DOC22/1095258

12 December 2022

**Parramatta Light Rail – Stage 2 (SSI 10035)  
Advice on Environmental Impact Statement (EIS)**

The EPA has reviewed the following relevant documents:

Figure 18.1 Contamination sampling locations - map 1

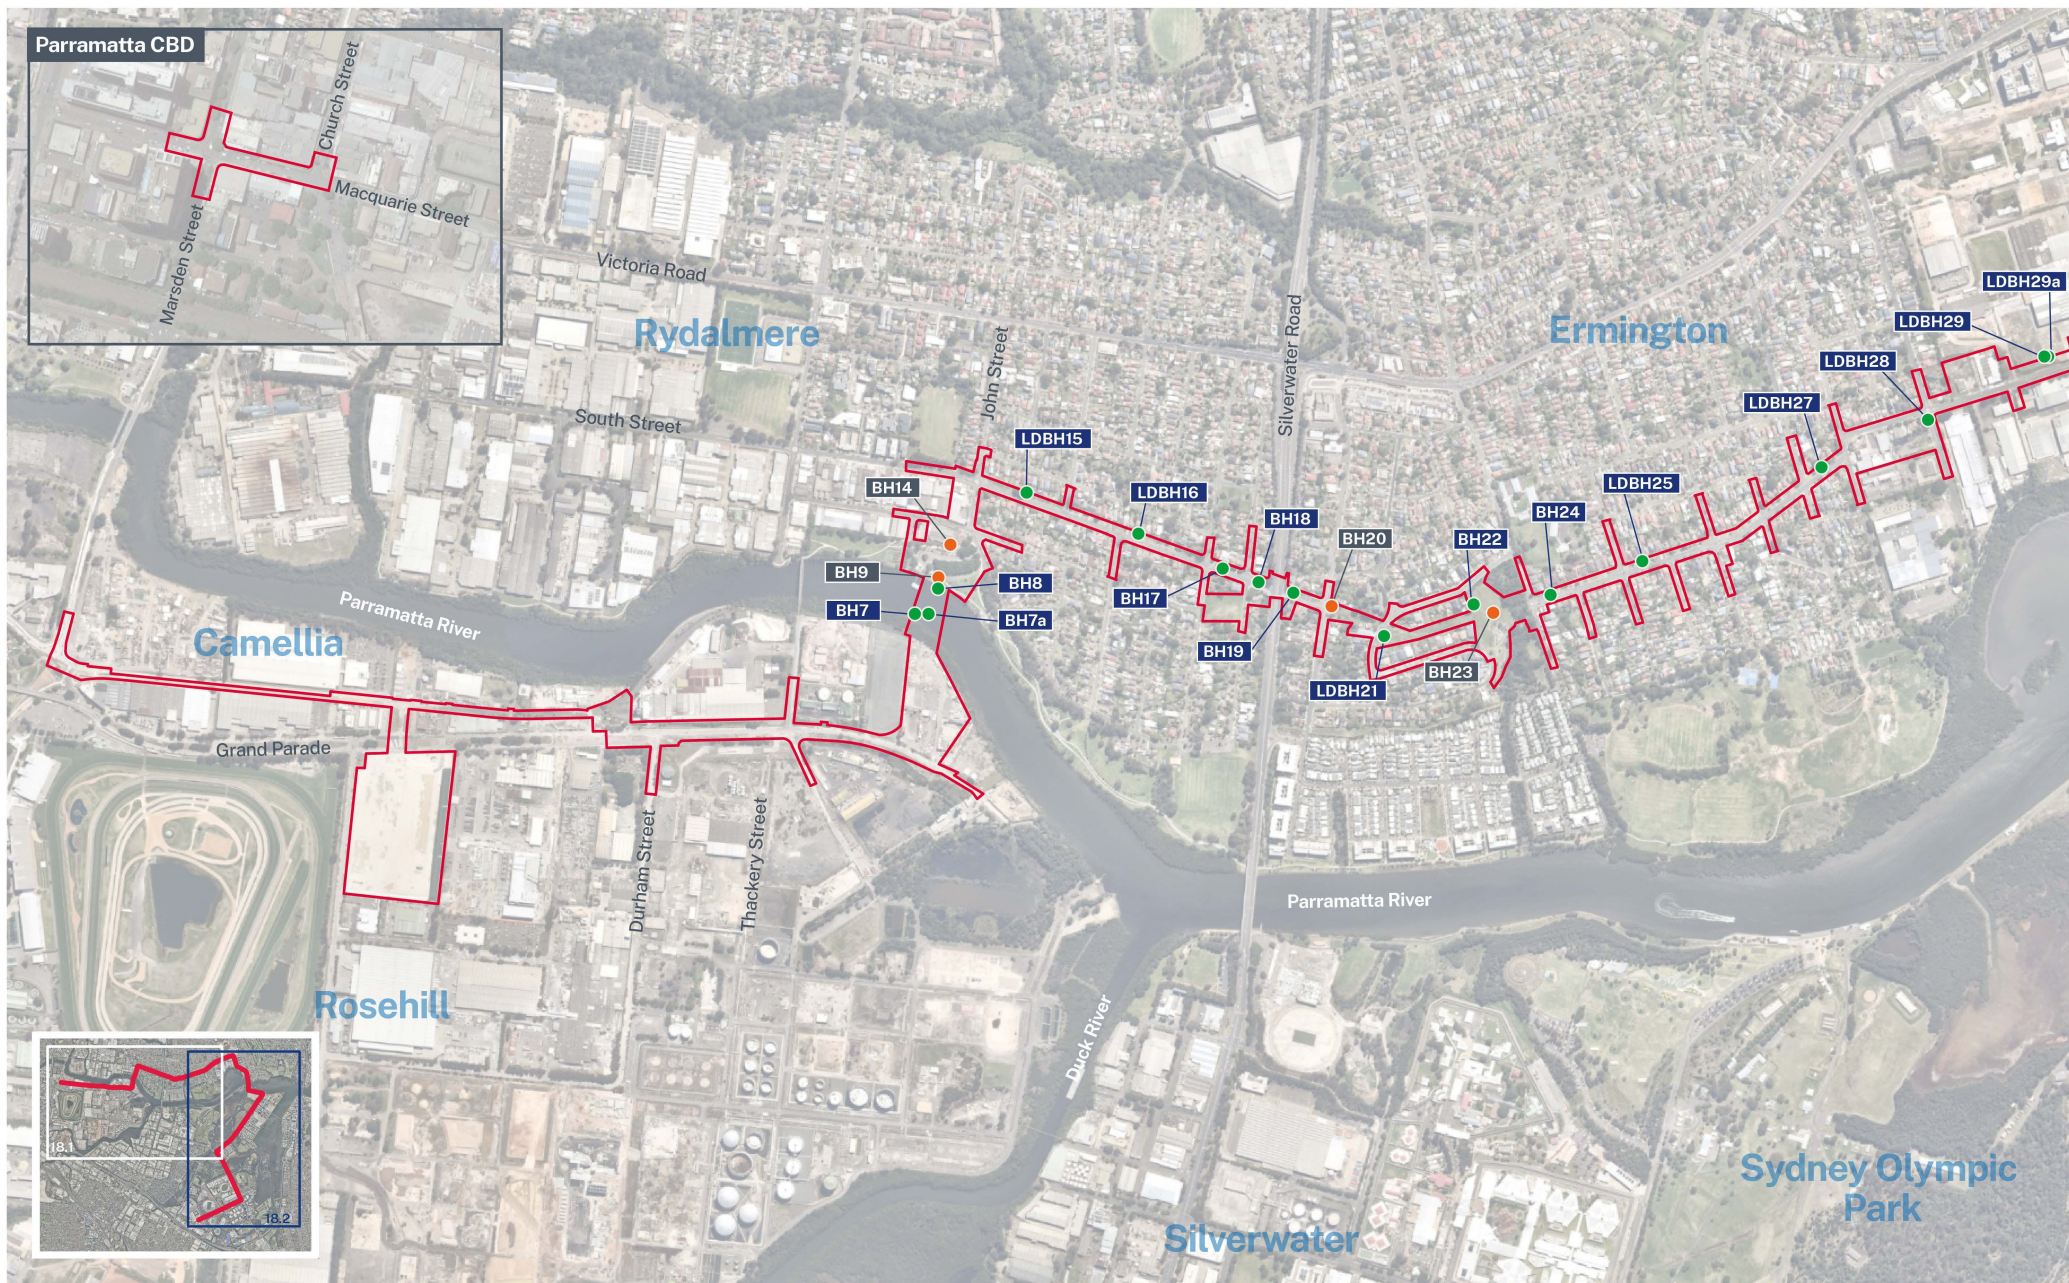
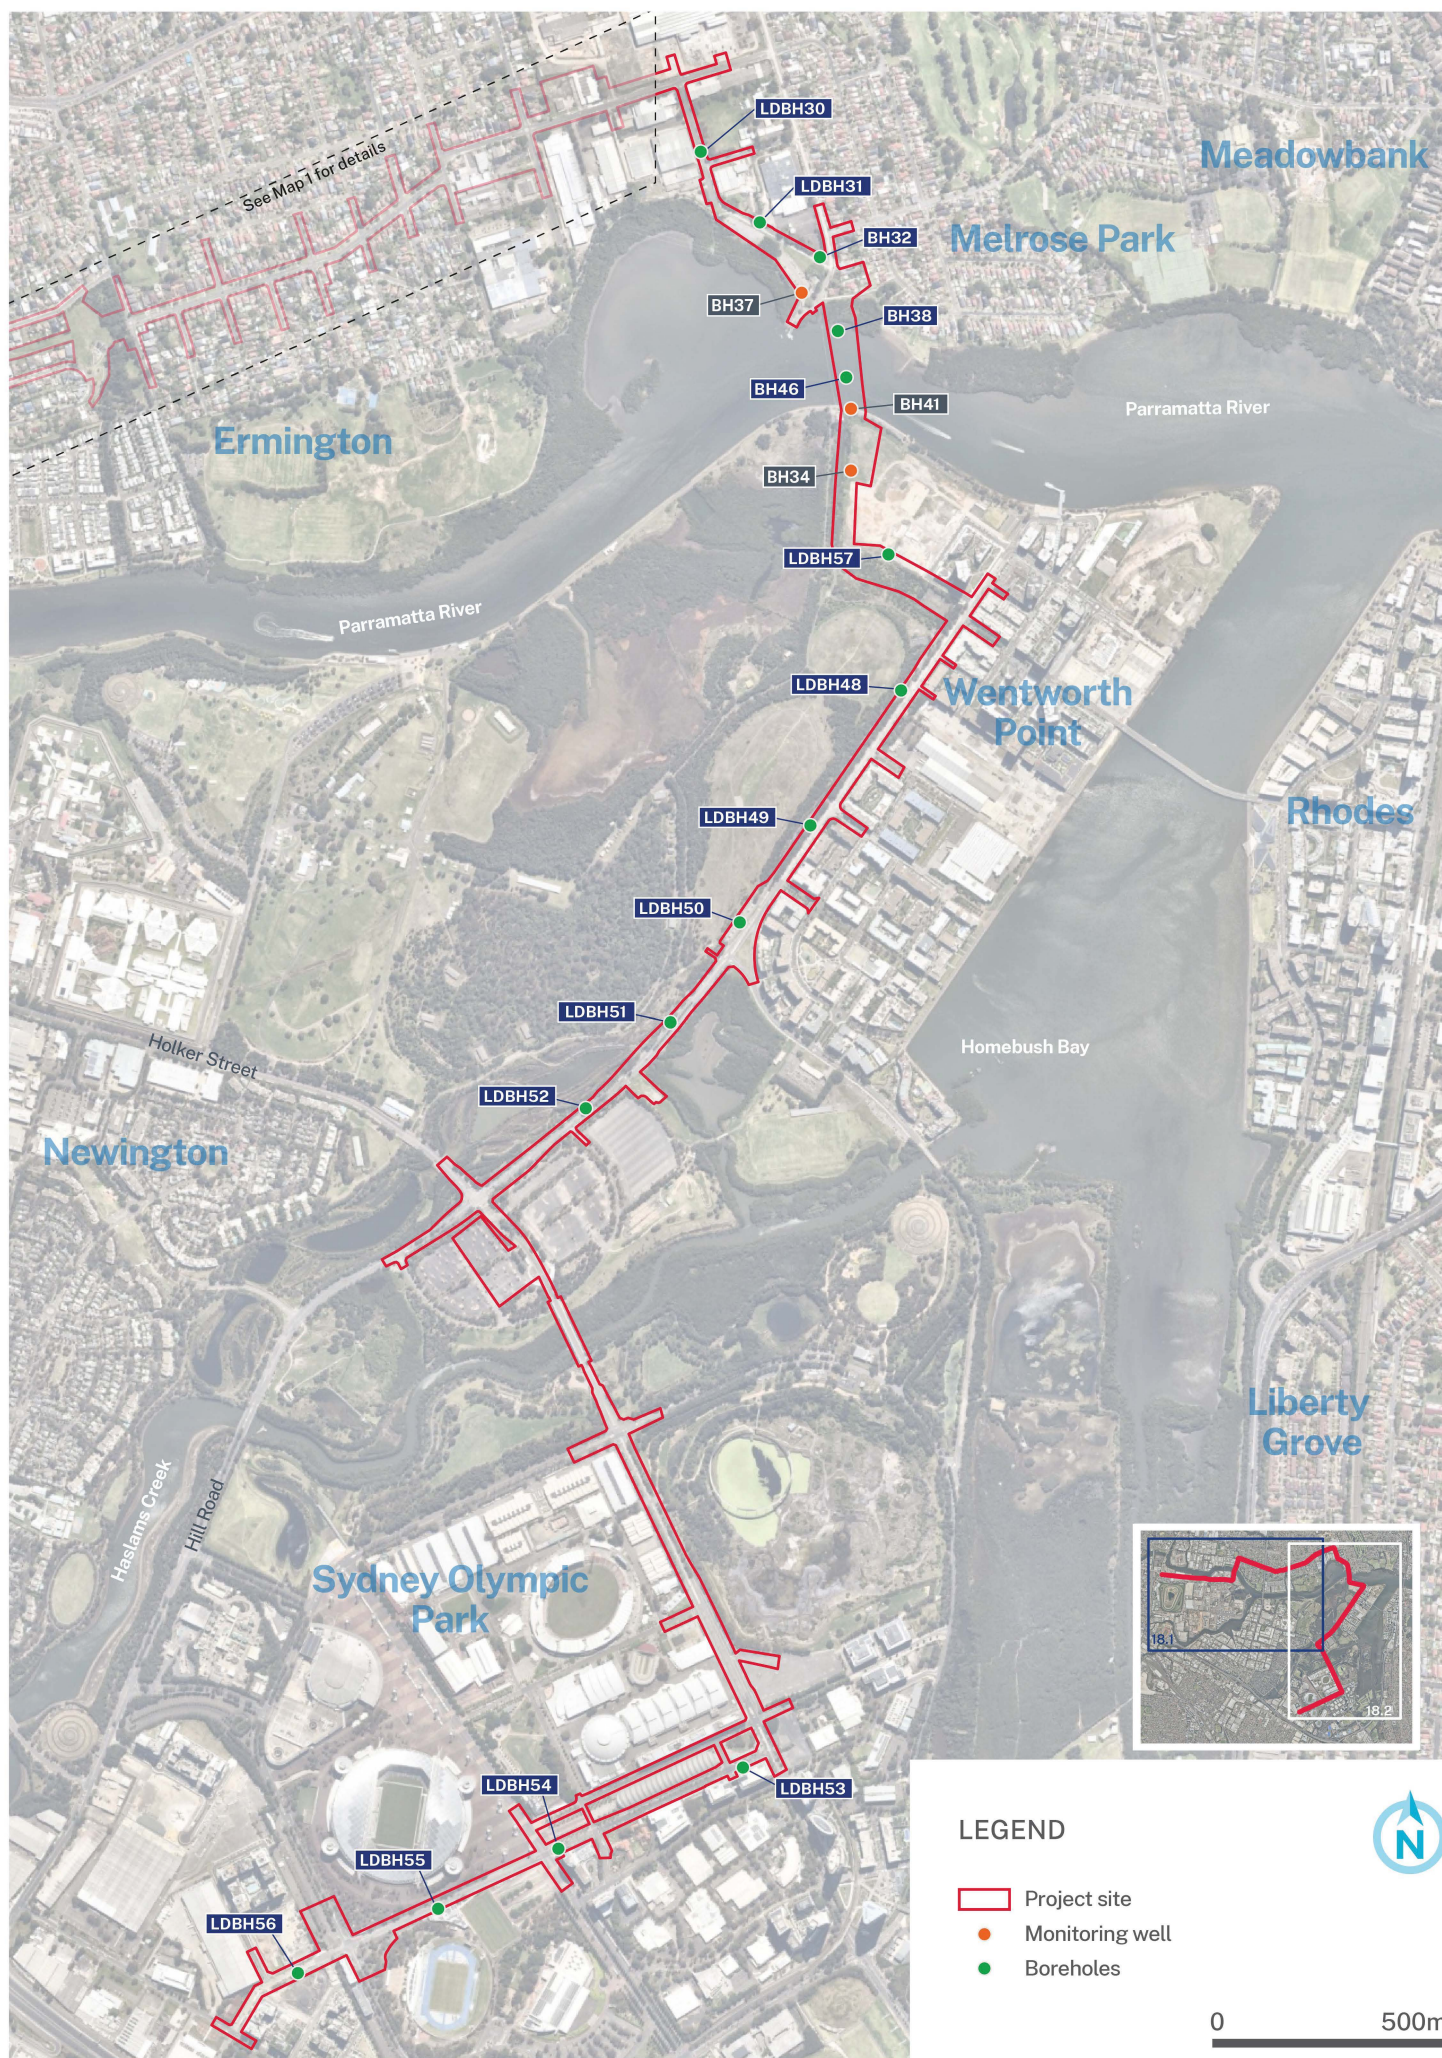
Chapter 18 states: *“further contamination investigation across the project site is currently underway, and will provide more information on contaminants present, their concentration in soil and groundwater, and their coverage across the project site. These additional sampling results would be used to inform further actions and decisions in relation to the need for remediation of areas and the approach to mitigation.”* **The EPA requests that the additional information be provided as part of the Response to Submissions.**

Figure 18.8 Historic landfills and associated infrastructure at Sydney Olympic Park

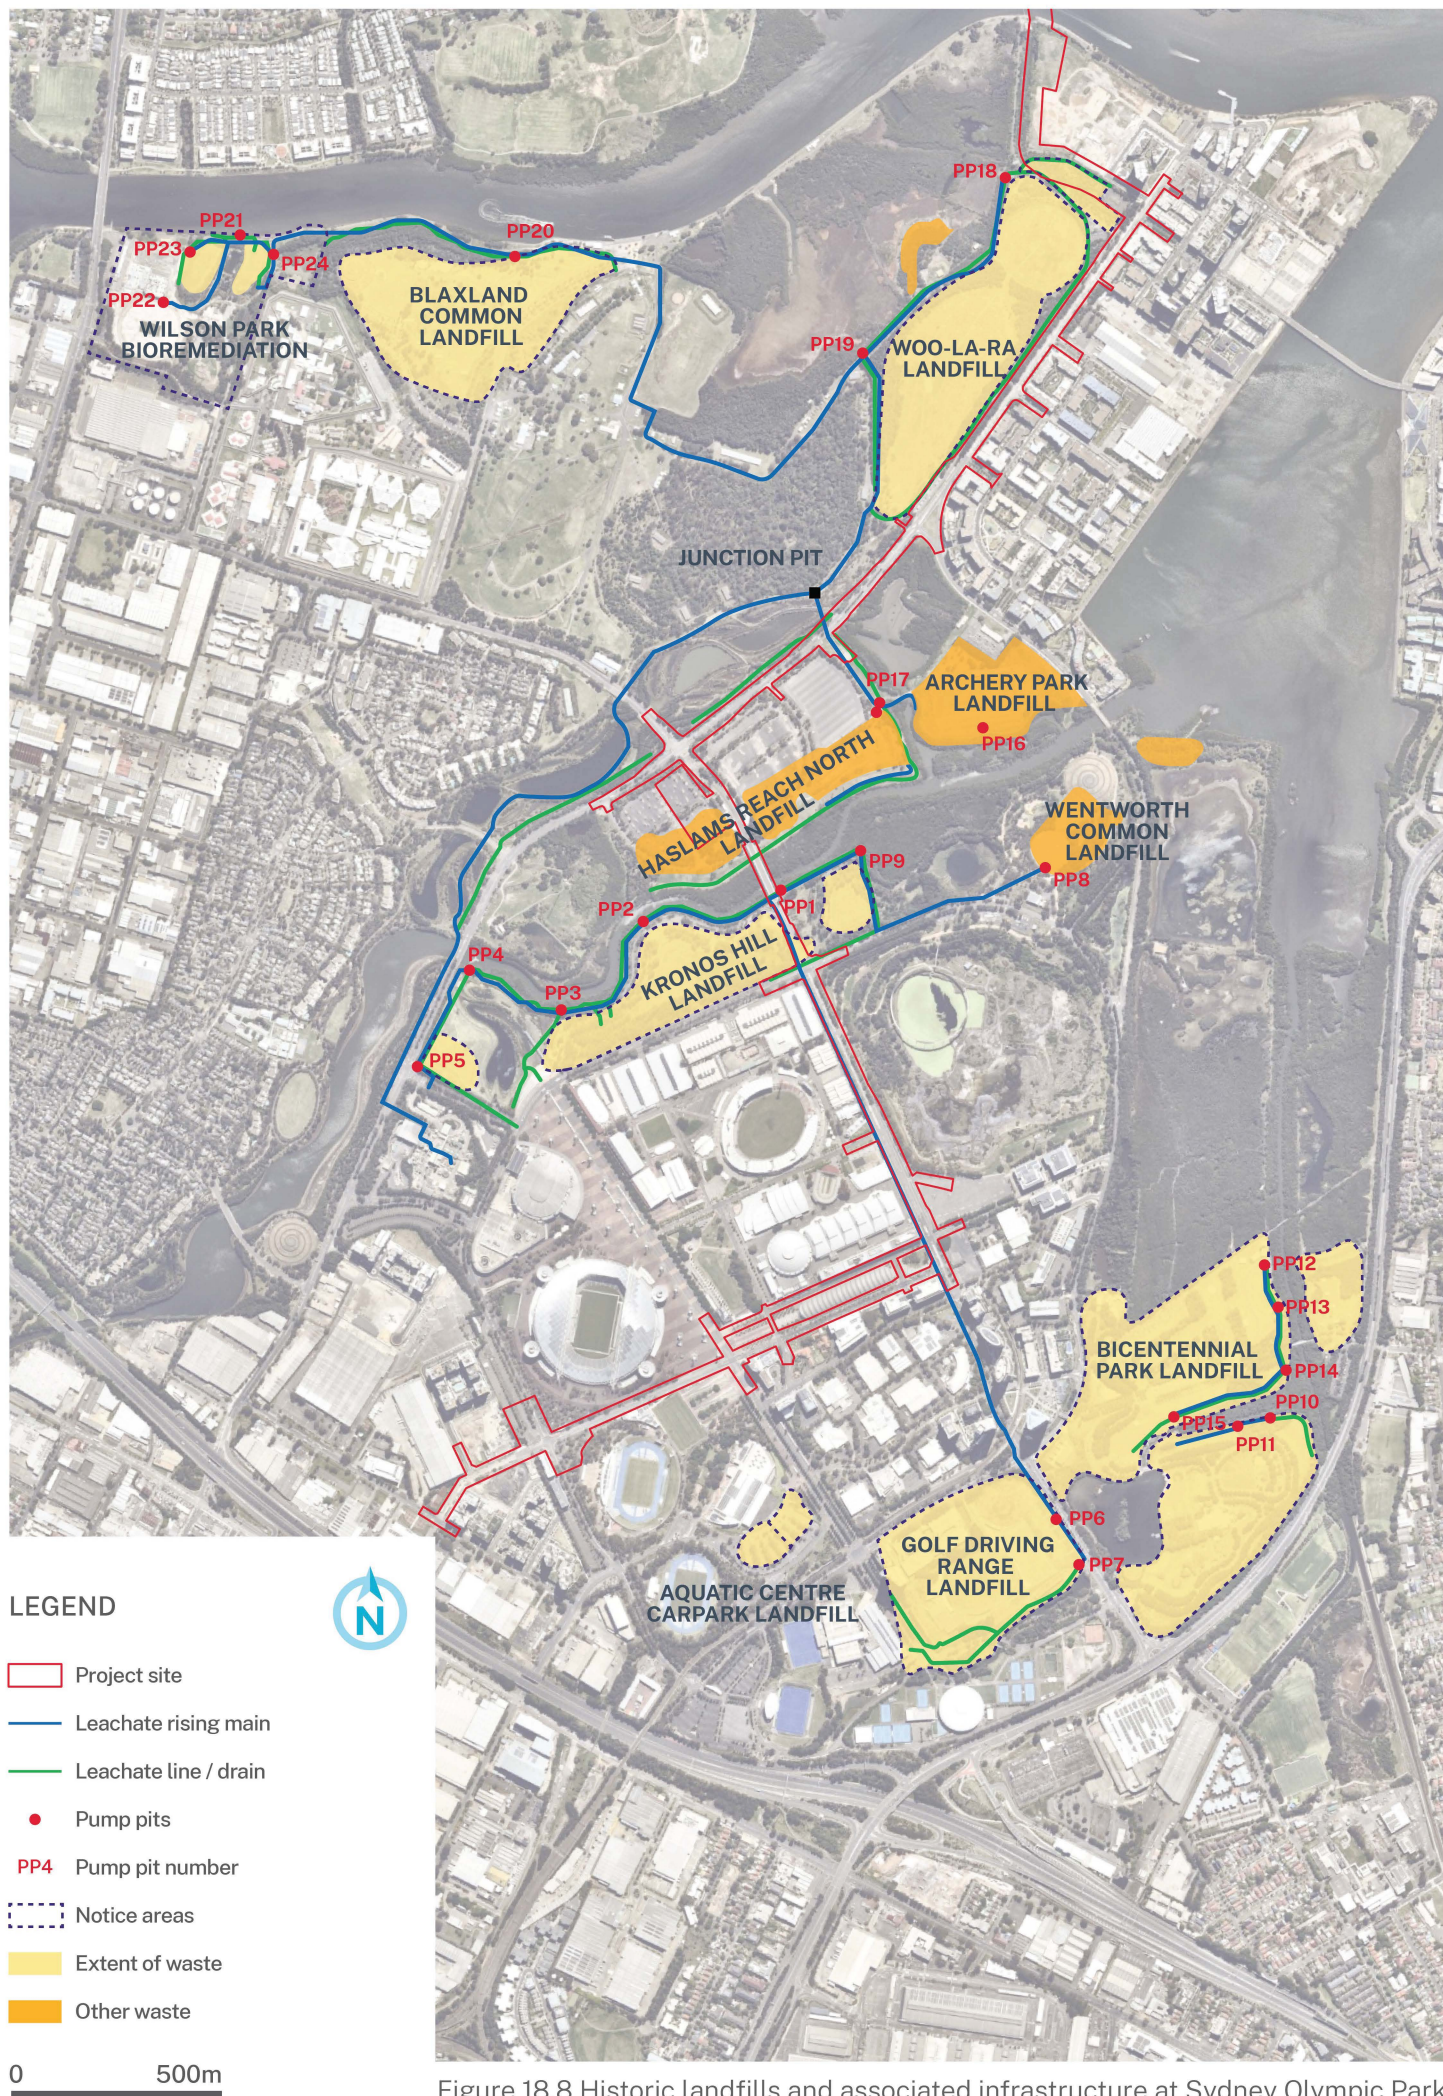
The alignment also intersects Haslam's Reach landfill and possibly other landfills located within Sydney Olympic Park. The following permissions and consents will need to be considered if excavating into landfills:

- a) Under Section 110A of the *Protection of the Environment Operations Waste Regulation 2014*, the proponent must obtain written consent from the EPA prior to any exhumation of waste from landfill sites.
- b) Certain landfills located in Sydney Olympic Park are regulated by the EPA under the *Contaminated Land Management Act 1997* through an Ongoing Maintenance Order issued to the Sydney Olympic Park Authority (SOPA). Under the Order, SOPA is required to obtain written consent from the EPA prior to undertaking excavations meeting a certain depth and area.

The proposed development presents a potential risk of damaging the landfills and leachate management infrastructure which services the Sydney Olympic Park landfills. These include remediated and engineered subsurface landforms, sub-surface drainage lines, pump pits, control boxes, piezometers, bores and so forth which appear to be located within the development footprint. Project interface with landfills and associated infrastructure must be managed appropriately to prevent damage to infrastructure, minimise risks to workers and the surrounding environment in exposure to contaminated leachate, hazardous ground gas, or soil contamination. The works must be designed to minimise the potential for a pollution event, and ensure infrastructure is reinstated to original condition. **The EPA recommends dilapidation surveys of landfill and landfill infrastructure to assist with reinstatement works.**
